Our Ref: R/134/20/NMA

Non-material amendment following grant of R/270/19/HH for the removal of approved glazed doors and juliette balconies to rear first floor extension and the addition of 2 No. velux rooflights to extension pitched roof.

1 Pigeonhouse Lane Rustington BN16 2AY

Drawing Number: 175 / P / 101 **Rev.**

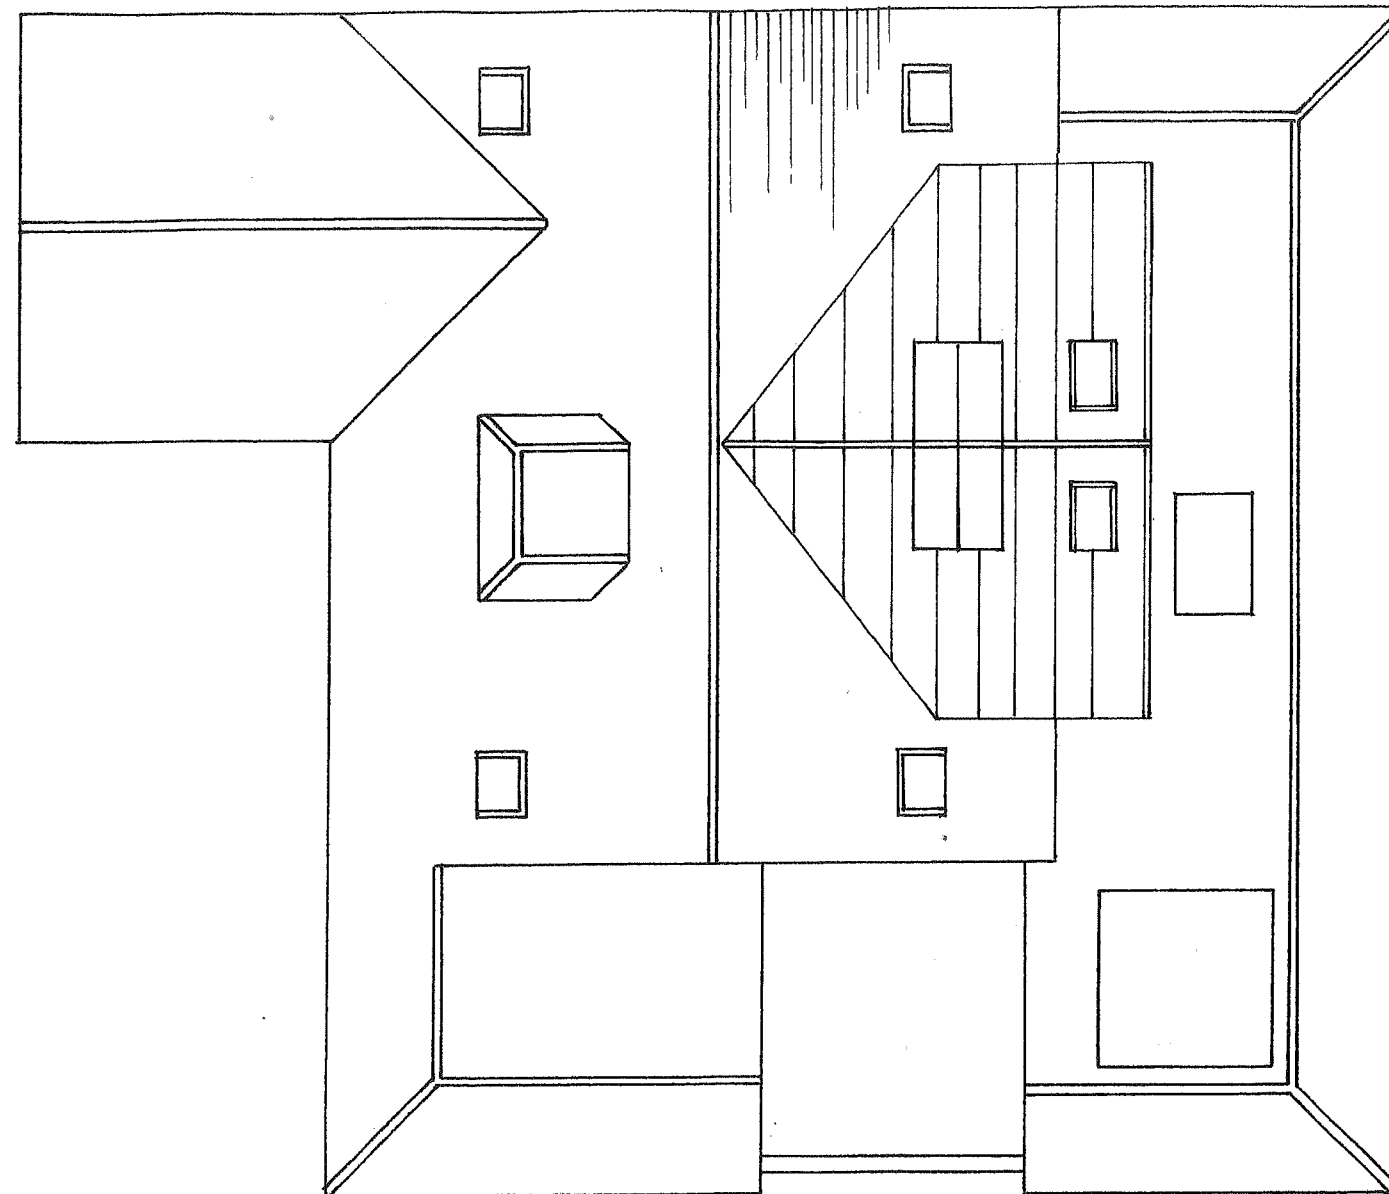
I refer to your recent application for a Non Material Minor Amendment. I note that you seek to remove the rear glazed door and associated Juliette balconies, and replace with 2No. Velux windows.

Please note that plans 'Proposed First Floor Plan - 154/P/007 - November 2019', 'Proposed Roof Plan - 154/P/008 - November 2019' and 'Proposed Elevations - 154/P/009 - November 2019' are now replaced by Proposed Elevations - 175/P/103 - July 2020', 'Proposed Roof Plan - 175/P/102 - July 2020' and 'Proposed First Floor Plan - 175/P/101 - July 2020'.
